Prior Notification for Permitted Development

Schedule 2 Part 3 Class MA

Development: Application for prior approval under schedule 2, Part 3, Class MA for proposed change of use from commercial, business and service (Use Class E) to Dwellinghouses (Use class C3).

Location: 17 Elmer Road Middleton-On-Sea PO22 6DZ

Drawing
Existing first floor plan

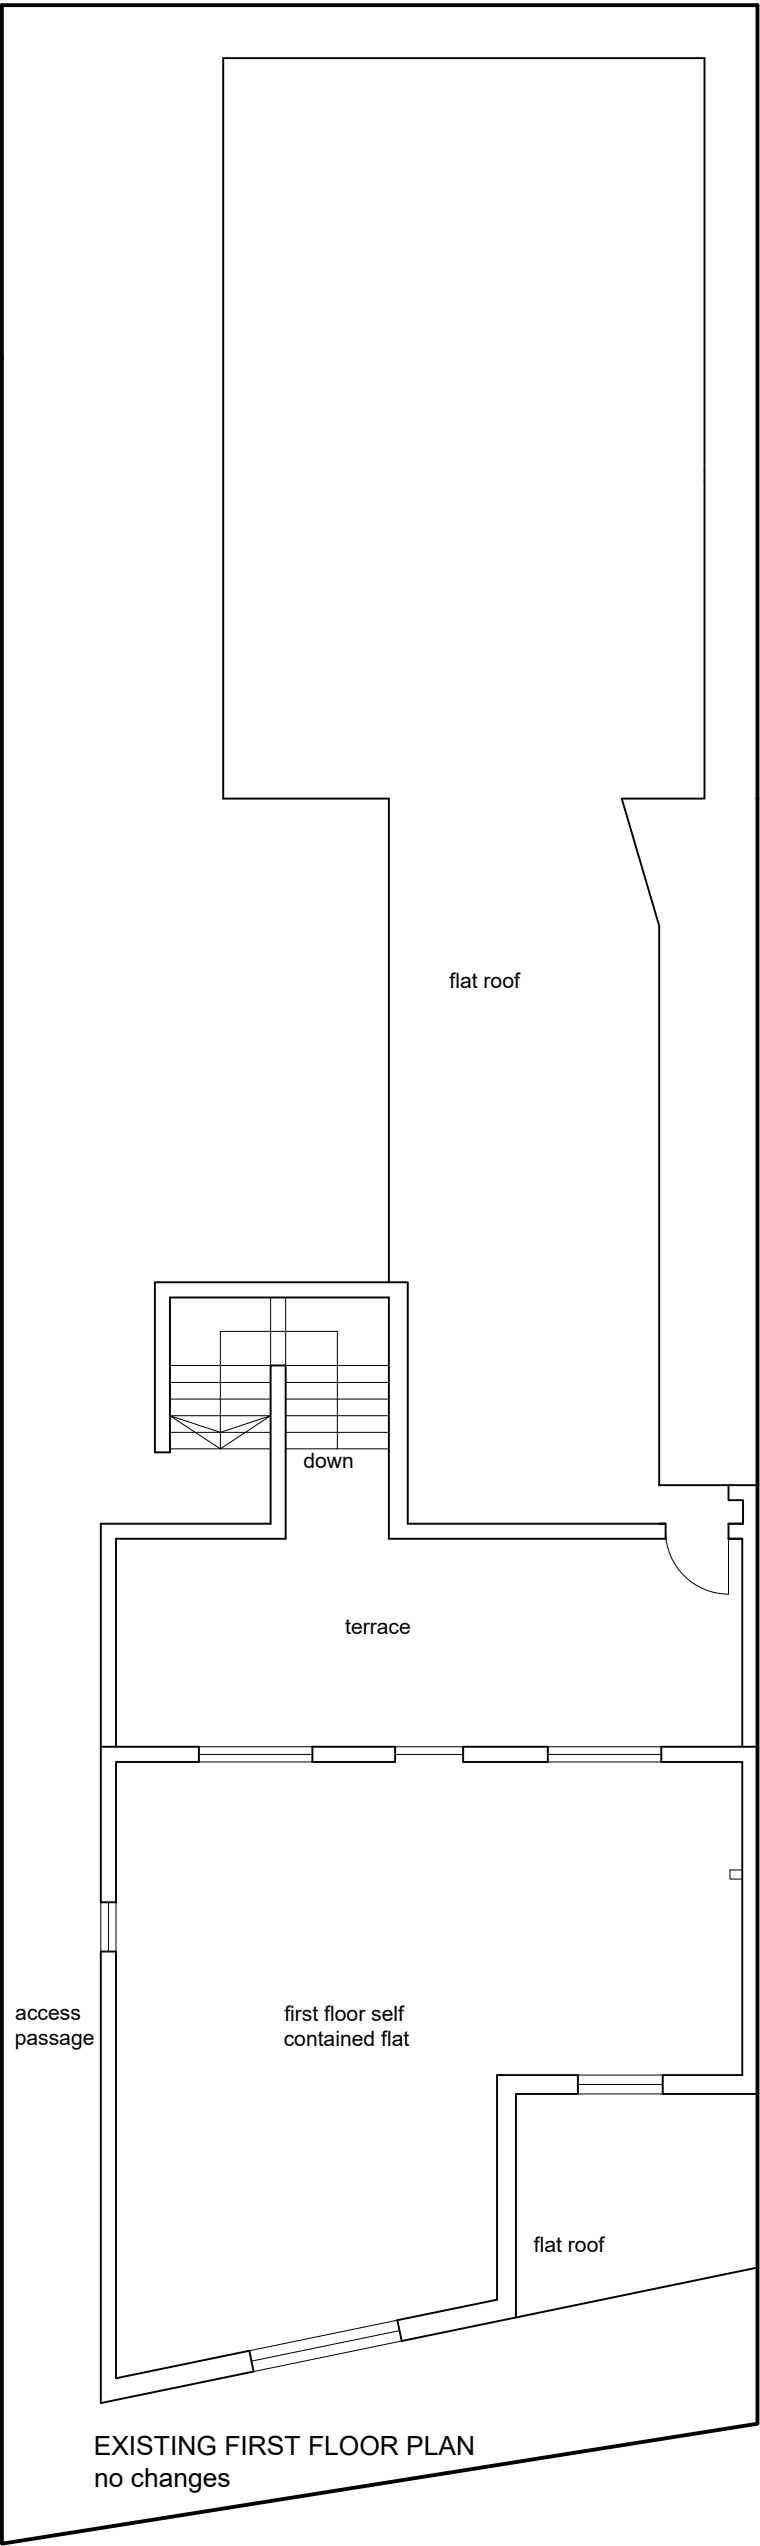
Floor Plans

Please can you annotate the floor plan to include all dimensions, including windows and doors as specified in the General Permitted Development Order.
